WEST SUSSEX COUNTY COUNCIL CONSULTATION

TO:	Arun District Council FAO: Hebe Smith
FROM:	WSCC – Highways Authority
DATE:	12 May 2026
LOCATION:	51a Aldwick Road Bognor Regis PO21 2NJ
SUBJECT:	BR/20/26/PL Retention of change of use of first and second floor office to a 5 bed HMO. This application is in CIL Zone 4 (Zero Rated) as other development.
DATE OF SITE VISIT:	n/a
RECOMMENDATION:	Advice

TITLE
Block Plan

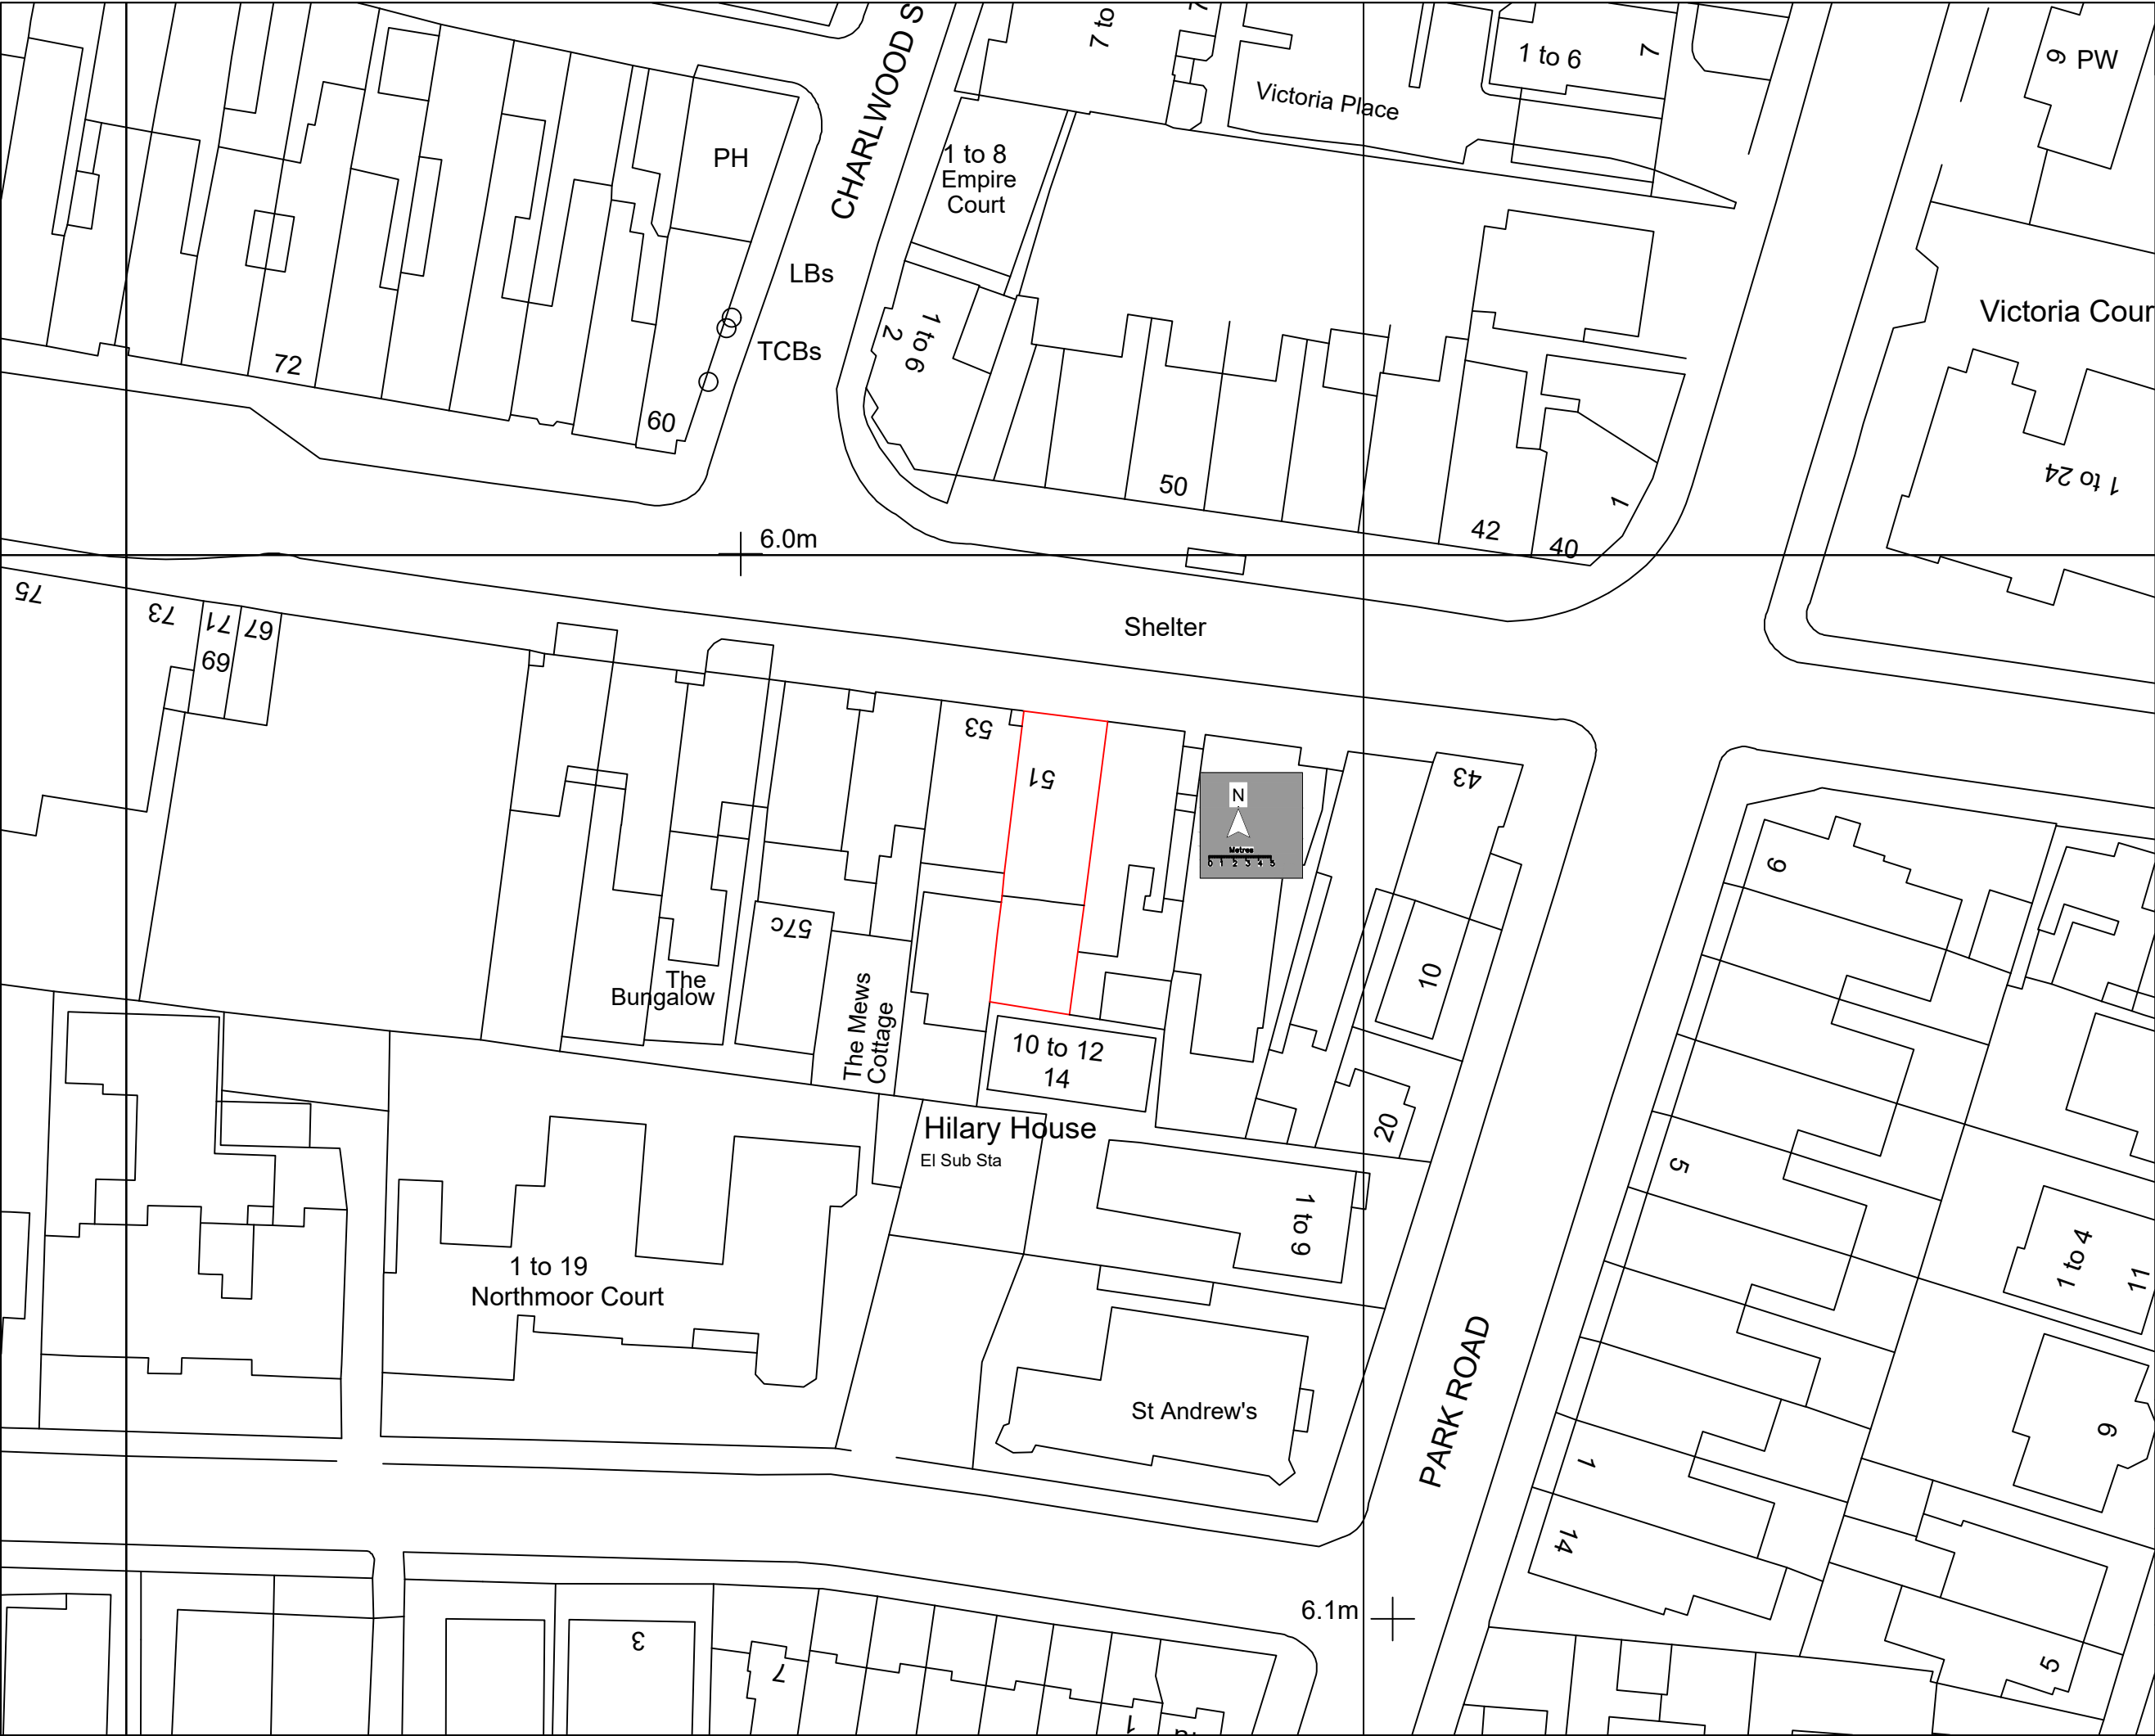
The site is situated in a sustainable location within walking/cycle distance of local services, amenities, and public transport links. Cycling is a viable option in the local area; however, a cycle parking provision has not been outlined within the submitted documentation. The Local Planning Authority may wish to consider a condition ensuring secure and covered cycle parking alongside any permission of the scheme, as there appears sufficient space within the rear curtilage to facilitate this.

No part of the development shall be first occupied until covered and secure cycle parking spaces have been provided in accordance with plans and details submitted to and approved by the Local Planning Authority.
